REQUEST

Current Zoning: N1-A (Neighborhood 1-A)
Proposed Zoning: CR (CD) (Regional Commercial, Conditional)

Approximately 4.85 acres located west of Steele Creek Road and north of the Interstate 485 ramp.

The petition proposes to develop a vacant property in the Steele Creek community with up to 122,500 square feet of self-storage uses.

REZONING CASE #: RZP-2023-092

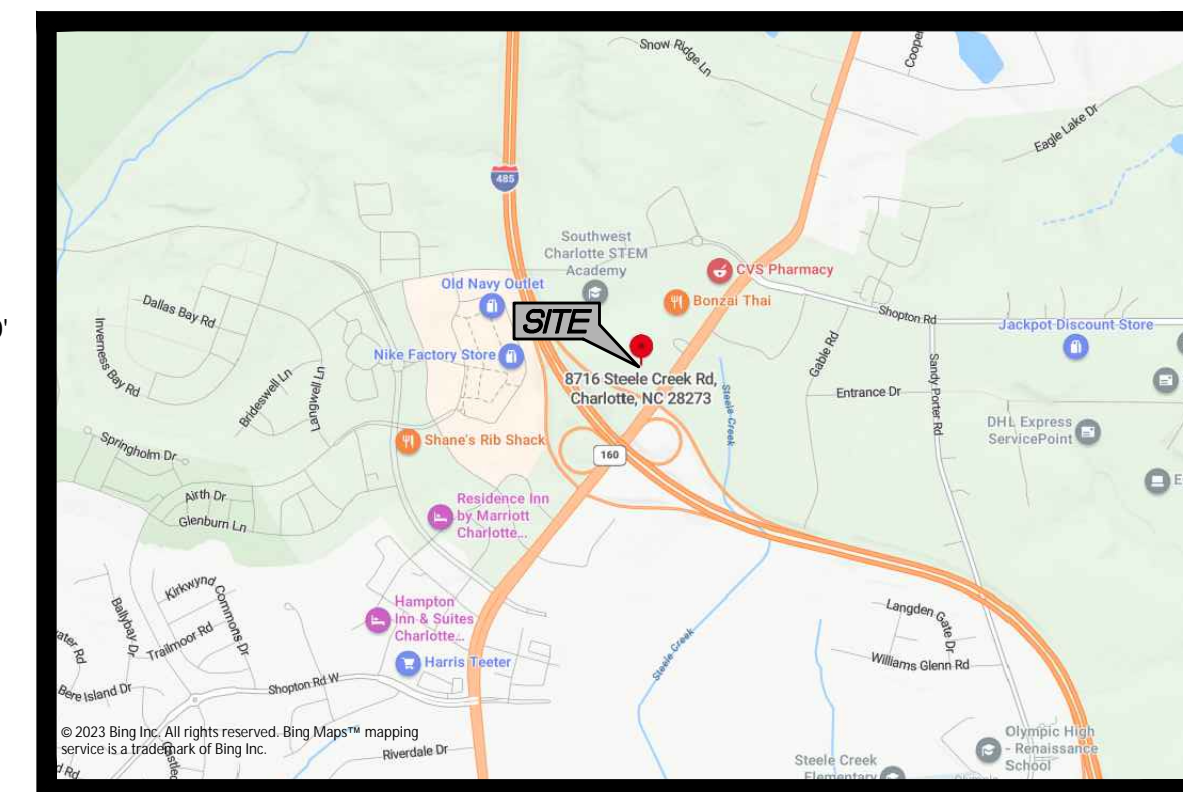
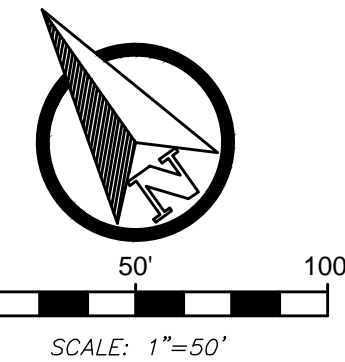
1. Adjust the square footages so that the maximum gross floor area equals the sum of the climate controlled self-storage and outdoor self-storage. **OUTSTANDING**
2. ~~Show tree save area on site plan. This site is required to provide a minimum of 15% tree save.~~
ADDRESSED
